Environmental Health Division
1675 W. Garden of the Gods Road
Suite 2044
Colorado Springs, CO 80907
(719) 578-3199 *phone*
(719) 578-3188 *fax*
www.elpasocountyhealth.org

Grant Minor Subdivision, MS-17-005

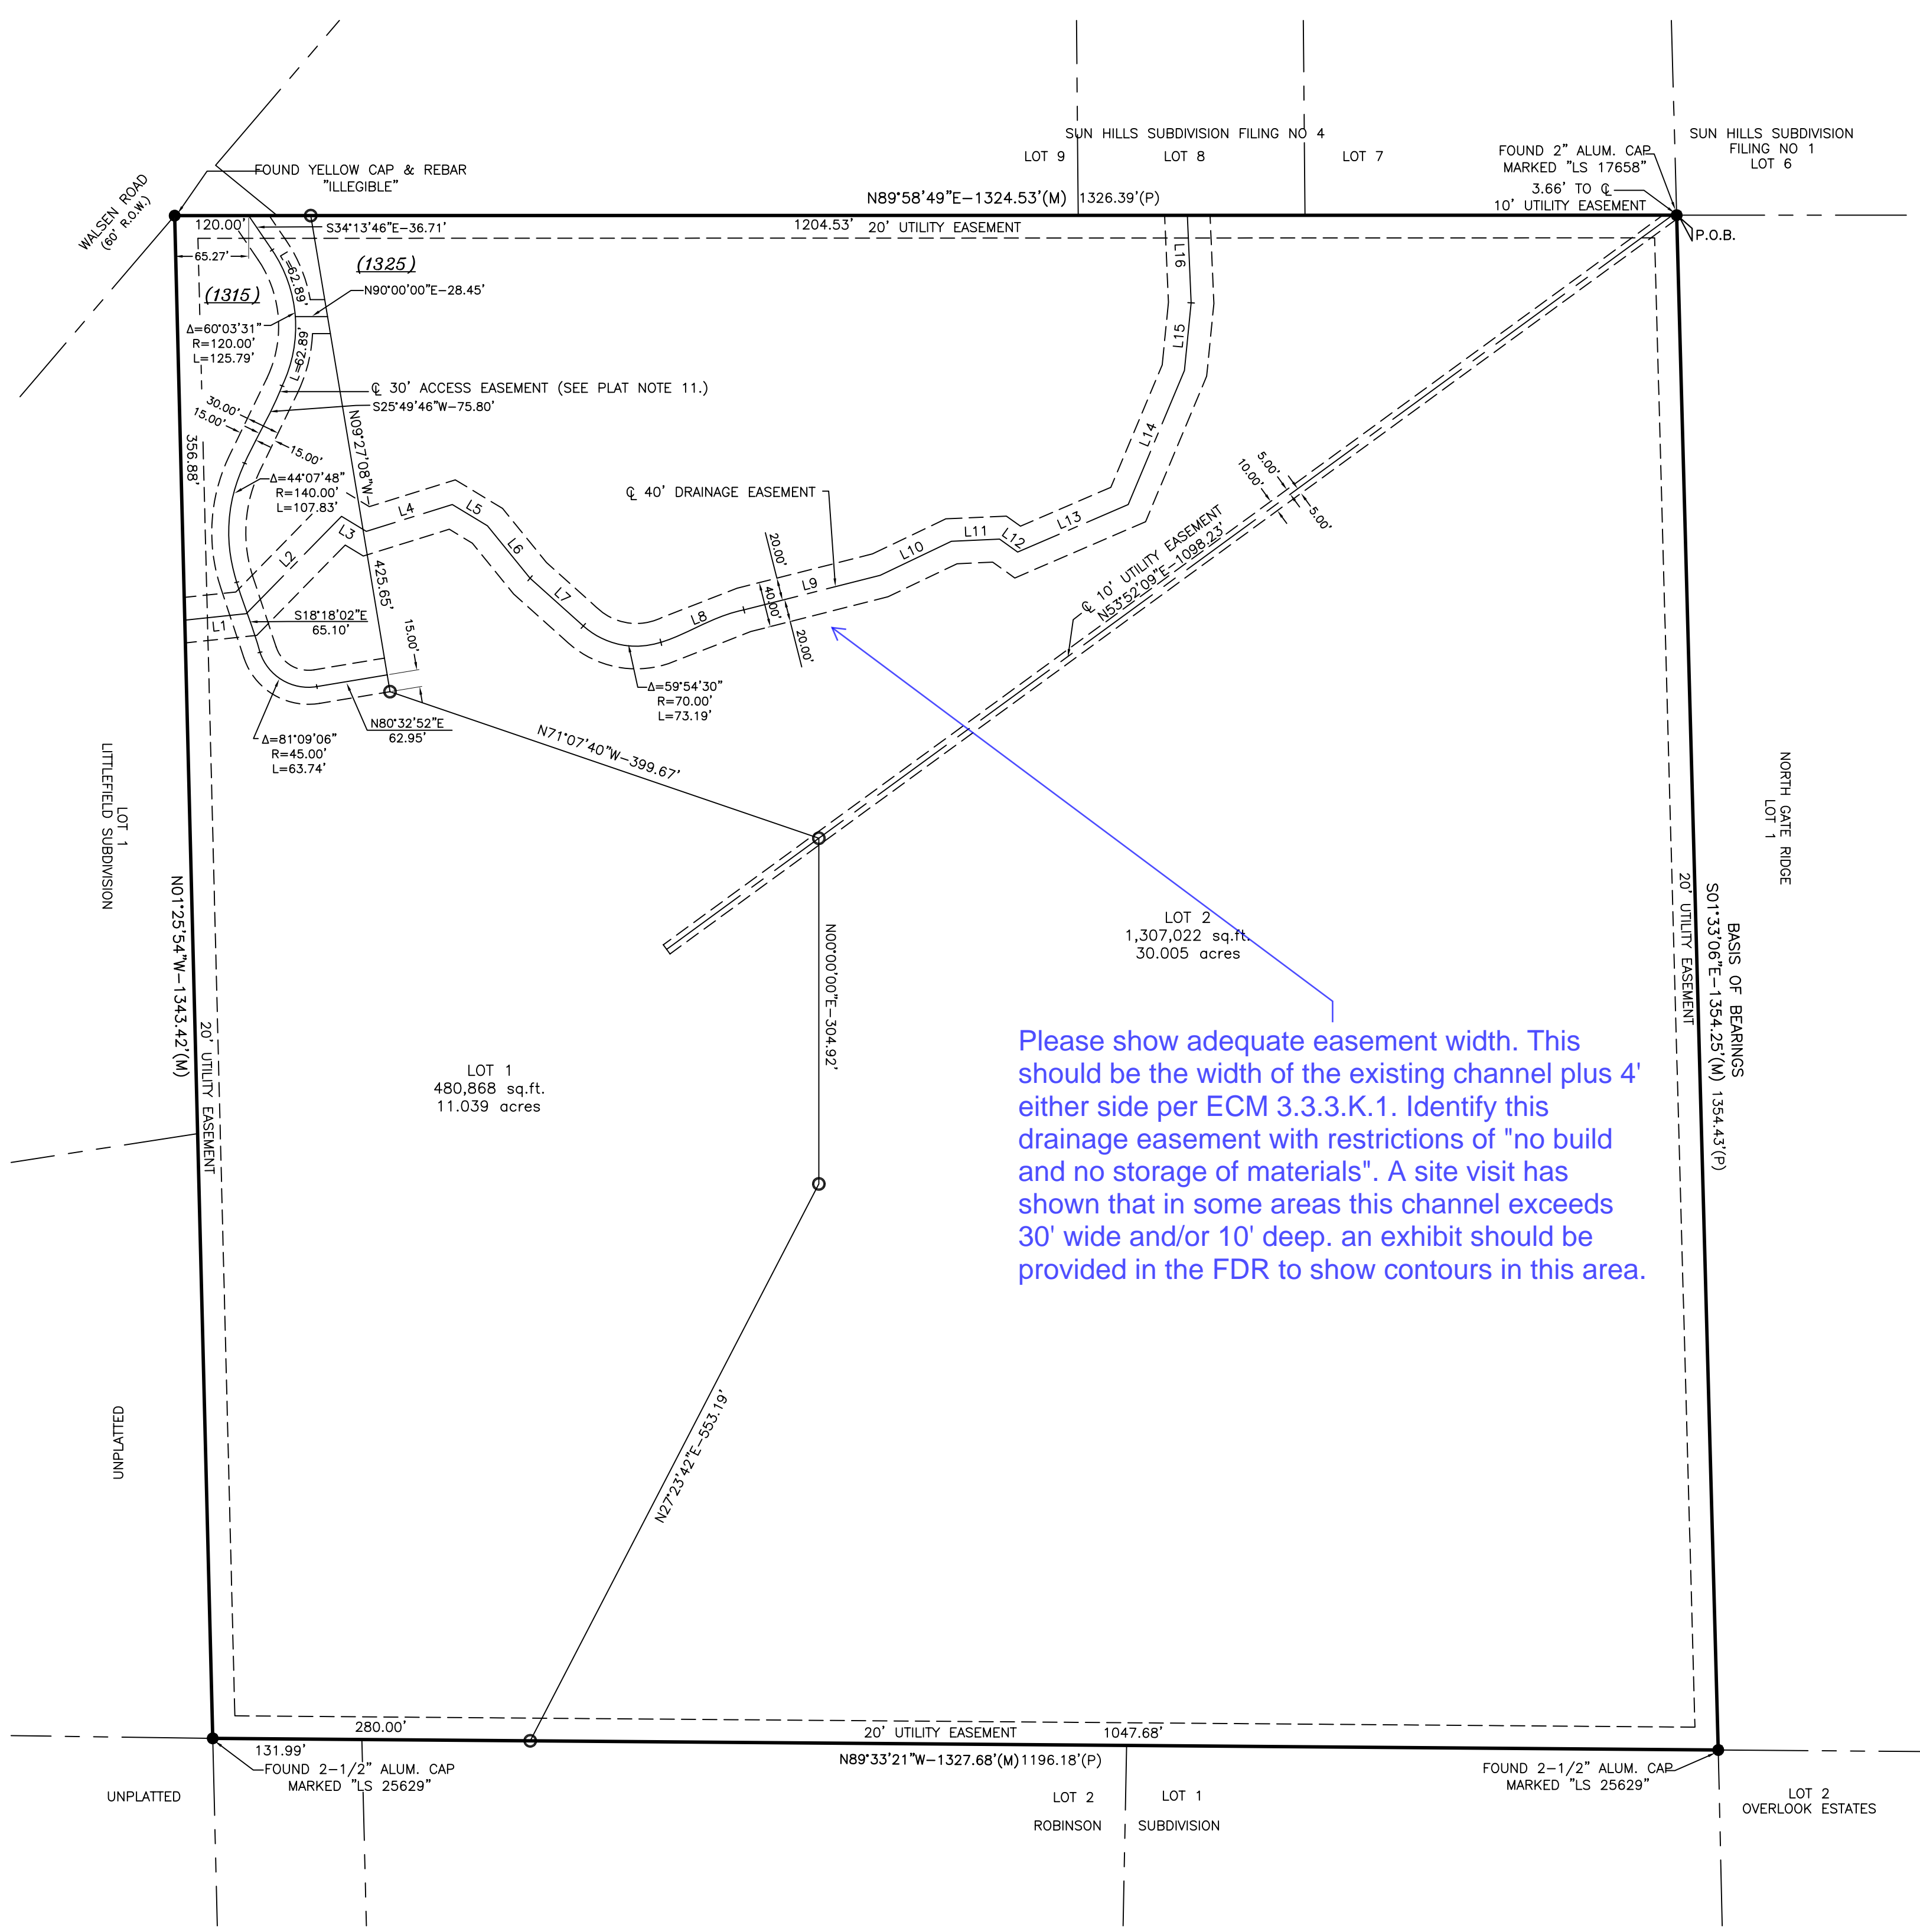
- The existing OWTS, soil treatment area (STA) must be 100' minimum from any well, and 10' minimum from the proposed new lot line.
- The proposed new lot (Lot #2) will require compliance with the El Paso County Board of Health Regulations, Chapter 8, Onsite Wastewater Treatment Systems prior to development. The future new STA's must be protected from any future construction and site development activities. Compaction of the STA by such activities may cause the area to be unsuitable for use. Recommend fencing the area during construction to minimize the potential for soil compaction. Adjacent property well locations were not shown on the Site Plan; therefore, be aware of the specific 100' setback requirements.
